Ribble Valley Borough Council
Housing & Development Control

Application no: **3/2021/1276**

Address: **Victoria House West Lane Worston Clitheroe BB7 1QA**

Proposal: **Proposed detached garage/office conversion to granny annexe.**

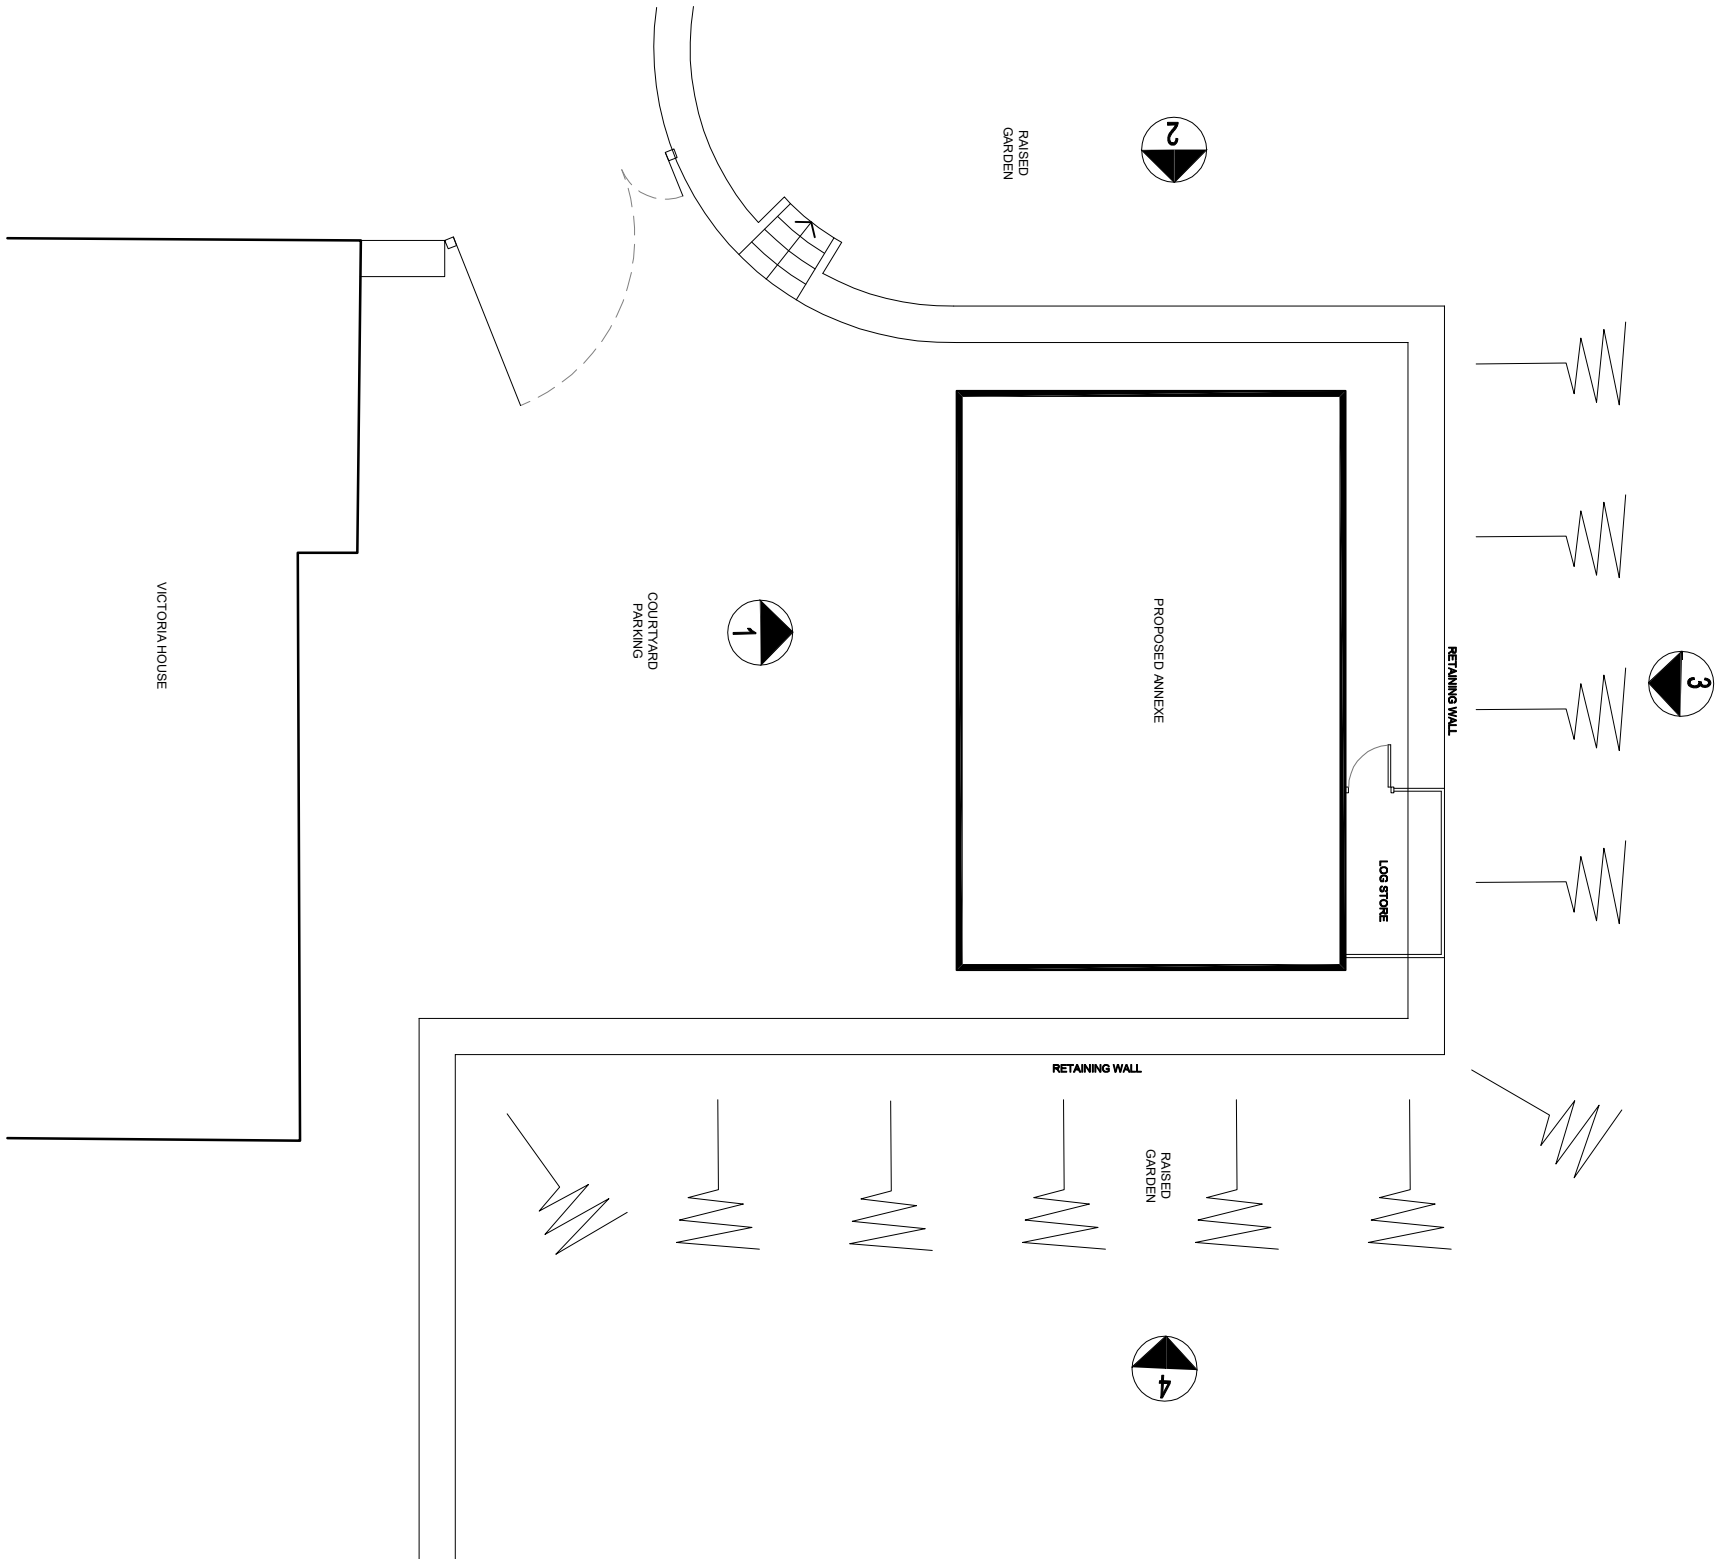
However, the parking arrangements of the existing dwelling will change with the use of the garage now being the detached one bed annexe.

While the site will lose the garage for parking, there is adequate space on the driveway to provide the required 3 car parking spaces for the existing dwelling and so the LHA have no comments to make.

The LHA will however condition, that the 1-bed annexe remains part of the existing dwelling and will not be used for commercial purposes without prior consent.

1. The annexe (detached building) hereby approved shall only be used ancillary to the enjoyment of the existing dwelling (household) and shall not be used by way of sale or sub-letting to form separate residential accommodation.
